**OXFORDSHIRE COUNTY COUNCIL**  
**TOWN AND COUNTRY PLANNING ACT 1990**

**PROPOSAL:**                    **Erection of 4no. dwelling houses with associated  
garages, access and landscaping**

**LOCATION:**                      **The Old Vicarage  
Fringford Road  
Caversfireld  
OX27 8TH**

**STATEMENT ON BEHALF OF THE LOCAL HIGHWAY AUTHORITY,  
OXFORDSHIRE COUNTY COUNCIL**

Site Plan
AS PROPOSED
Scale 1:200

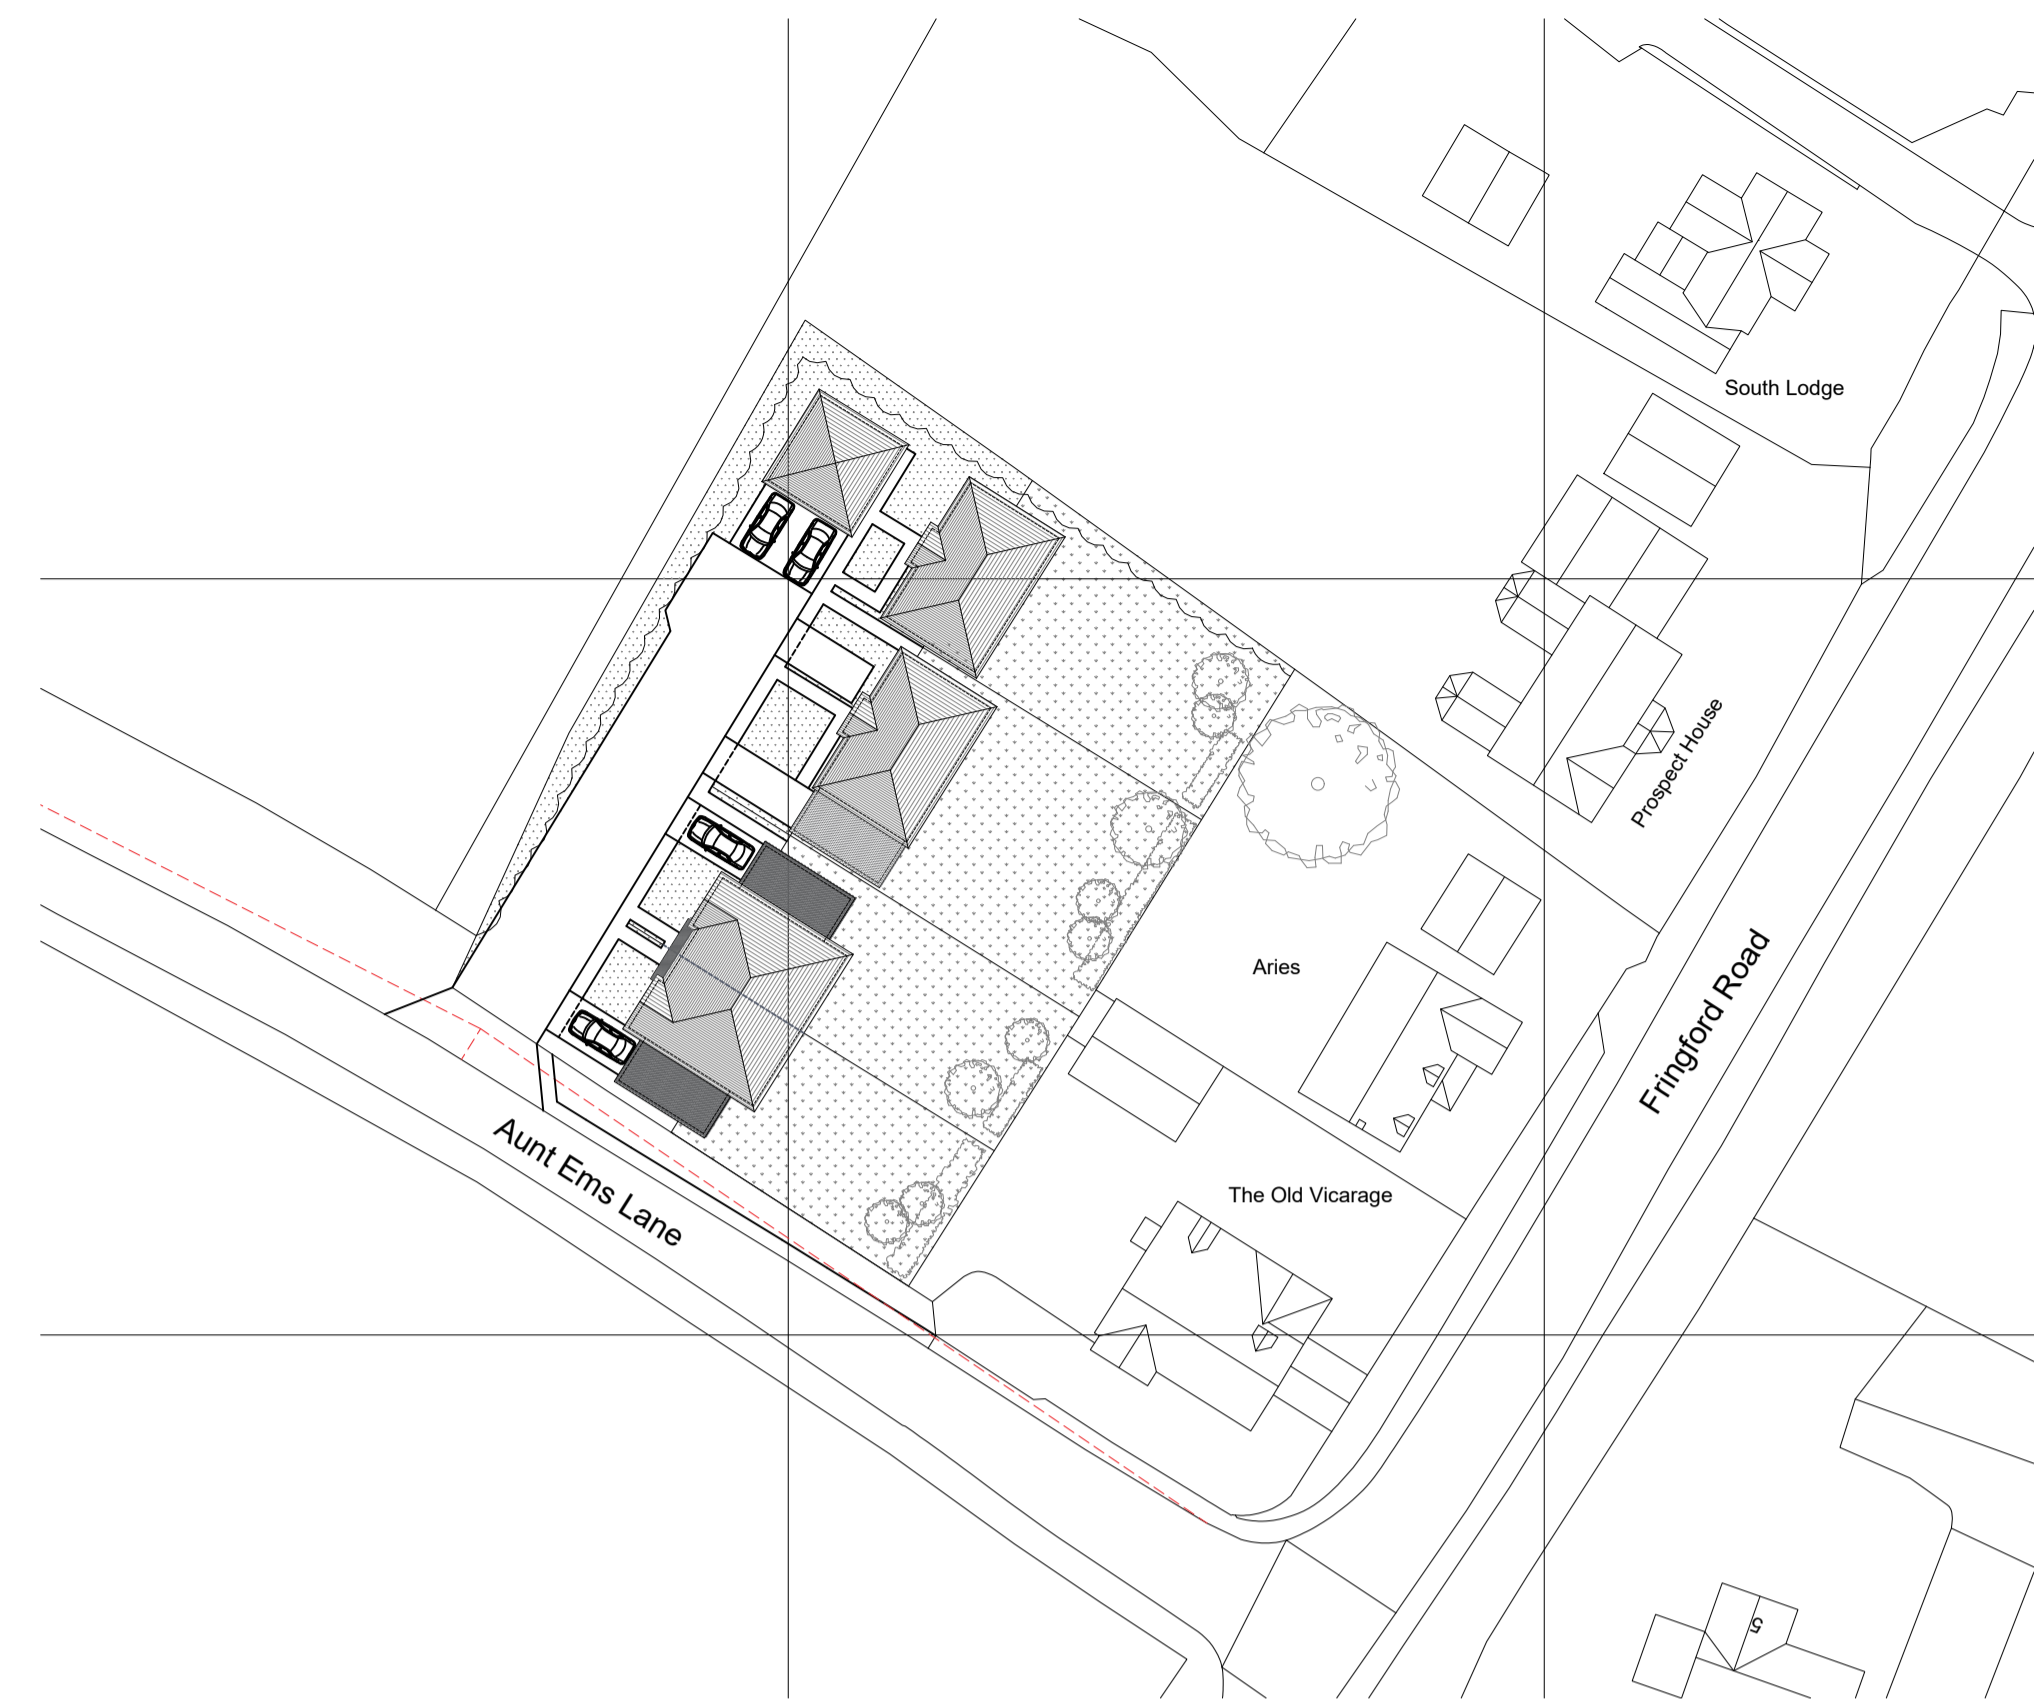
*The site layout plan does not show the full extent of the visibility splay to the west of the site access, nor does it indicate the dimensions of the visibility splay. The length of splay required to the west must be based on a speed survey at the location of the proposed site access and the visibility splay cannot extend over third party land. It may be possible to achieve the required visibility splay within the highway boundary however the current application has not demonstrated this. On this basis the county council must object to the application as it currently stands.*

9.5 As an example, if the 85<sup>th</sup> percentile was determined to be as low as 40mph, the visibility splay would need to be 103m, according to the DMRB. It is not certain that the required visibility splay can be achieved within the highway boundary.

9.7 Drawing No. 4176-P-03 Rev. A does show a red dashed line (as can be seen in Fig. 4) which is assumed to indicate a vision splay. However, there are no dimensions given, and the full extent to the north-west is not included. Nor is there any attempt to justify the length of the splay.

9.8 For this reason, the LHA has objected to the application as there will be no guarantee that an adequate visibility splay can be achieved to the north-west, resulting in a risk to highway safety.
